From: Linda Kane [REDACTED]
Sent: 16 May 2018 11:15
To: Planning
Subject: Planning application A/64/18/T

I am objecting to this application by Caffyns to fell two large mature copper beeches on their development site.

Drawing title
Site Plan

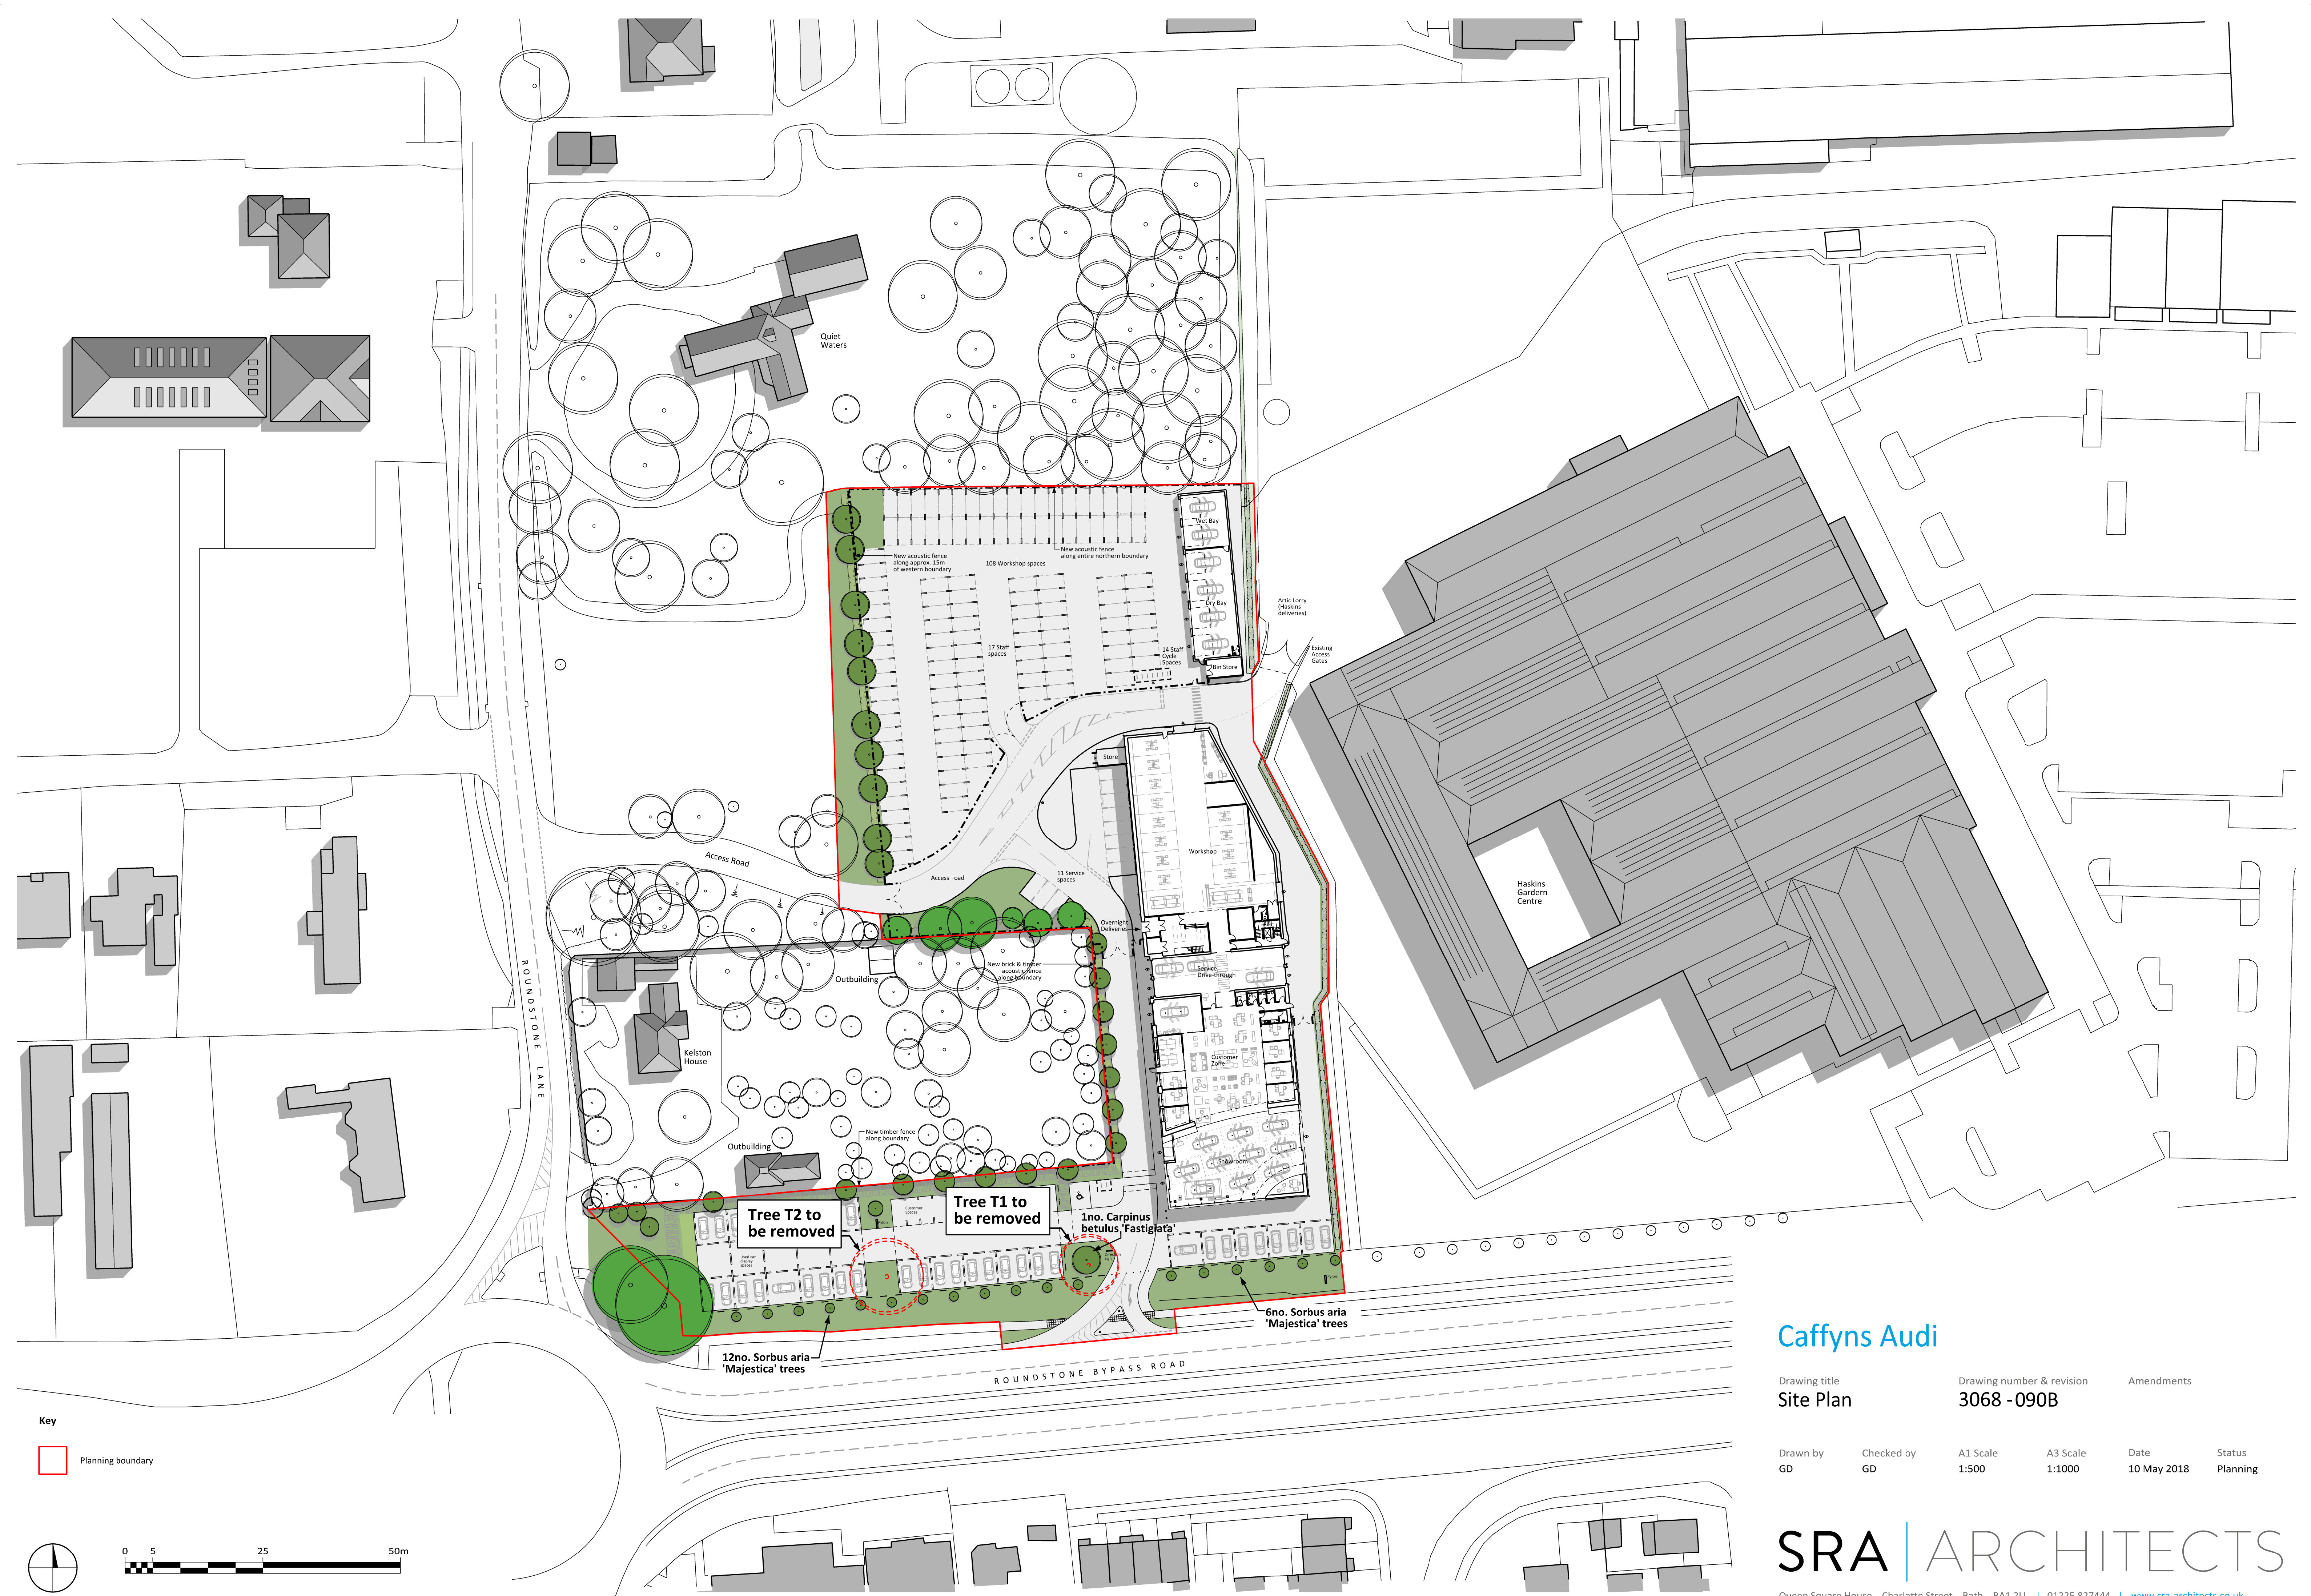
It is obvious from the layout of the kerbing for the car park and slip road that there was no intention by the developers to keep the trees.
